## EL PASO COUNTY GRADING AND EROSION CONTROL PLAN CHECKLIST

Revised: October 2021

SHEET **2** OF **7**

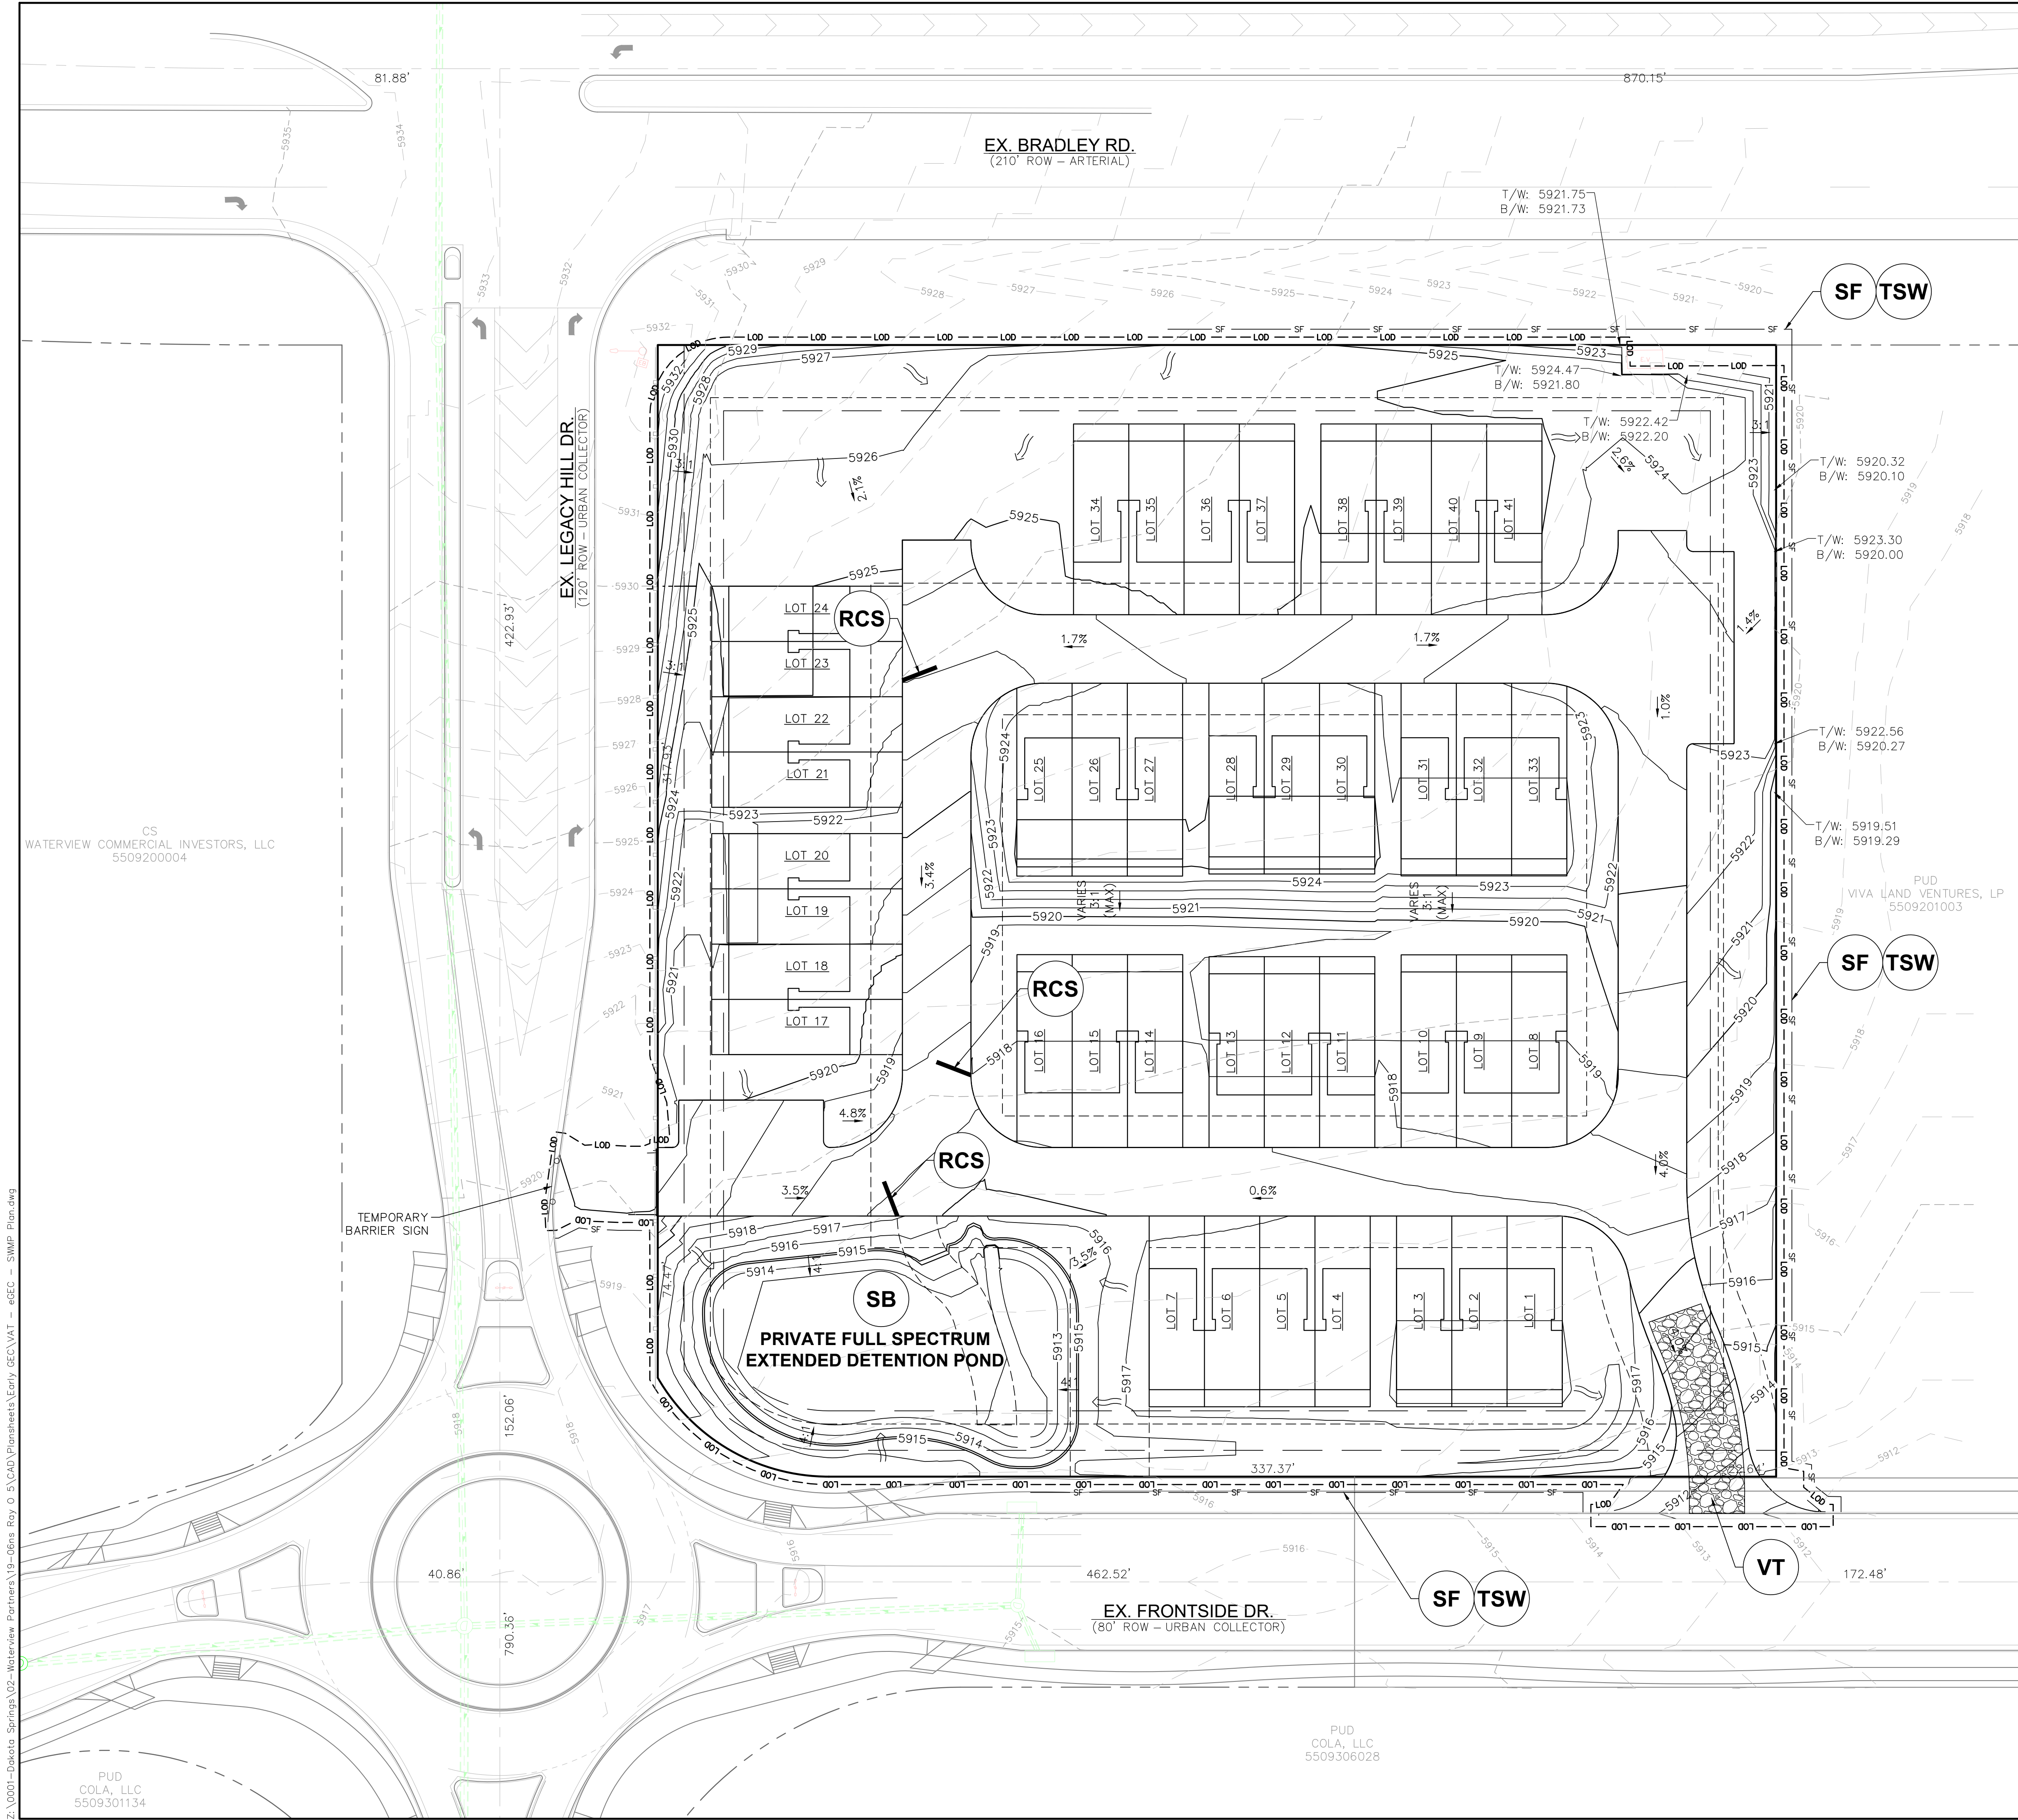
Revise notes on Sheet 2 of planset to match all of these notes.
